**KIRKLEES METROPOLITAN COUNCIL
INVESTMENT & REGENERATION SERVICE**

**DELEGATED DECISION FOR DISCHARGE OF CONDITION -
NOTIFICATION OF A CHANGE OF USE UNDER THE ABOVE
PROVISIONS**

Reference no. 2025/CL/92815/W

**Description Prior approval for installation of
solar photovoltaic (PV) panels and
associated works**

Drawing No.: HDS-240251-PLN

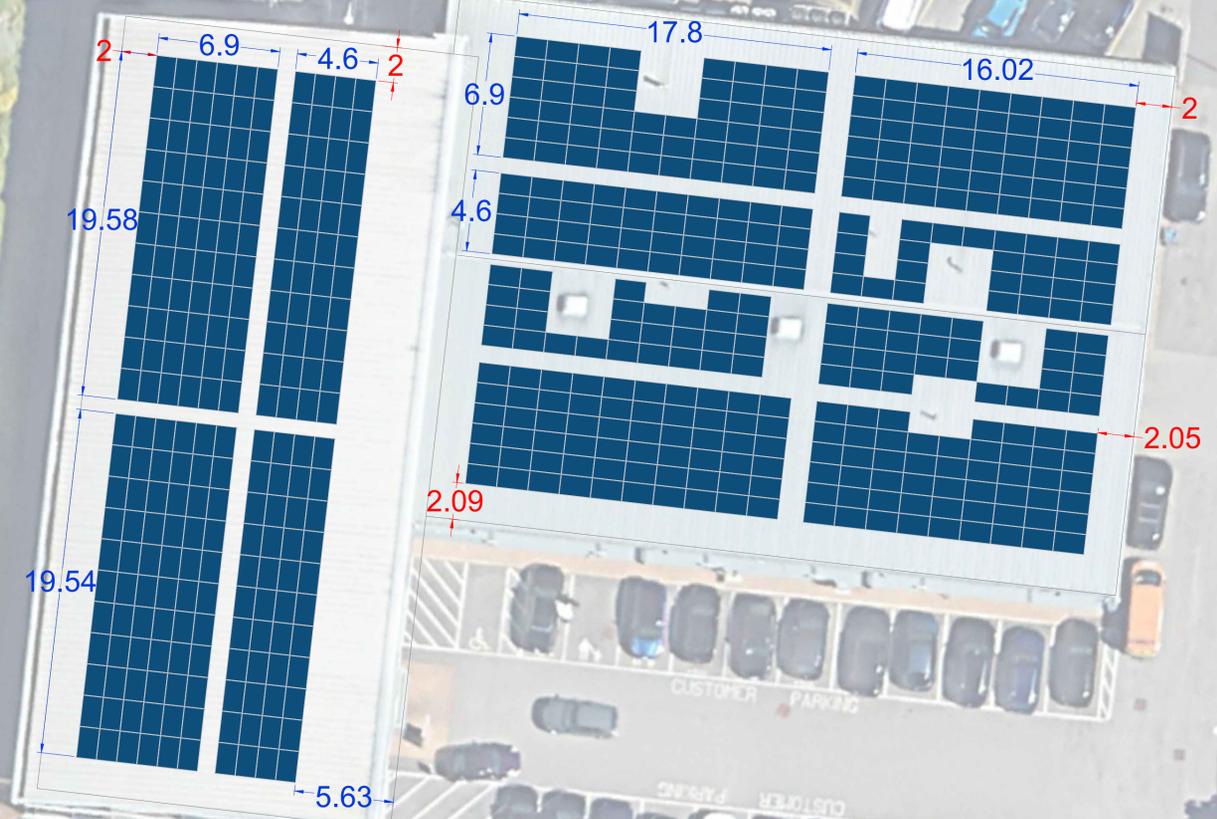
Solar panels will be installed across the two the main roof planes the application building, set in a grid format as indicate on the submitted block plan. The panels will be set away from the side of the roof.

Details of the placement of each solar panel have been submitted via plans (HDS-240251-PLN).

Comment: The solar equipment are to be installed on a pitched roof but would not protrude more than 0.2 meters beyond the place of the roof slope.

Comment: The application form states that the panels would not be within 1 metre of the external edge of the roof.

The proposed solar panels are to be installed on the roof of the existing building. Owing to the building's height and overall form, the majority of the panels are unlikely to be prominently visible from neighbouring properties. Some visibility may occur on the sloping roof plane facing Leeds Road, particularly for occupants of nearby buildings and road users; however, this visibility is limited by the shallow roof pitch and the set-back position of the arrays.
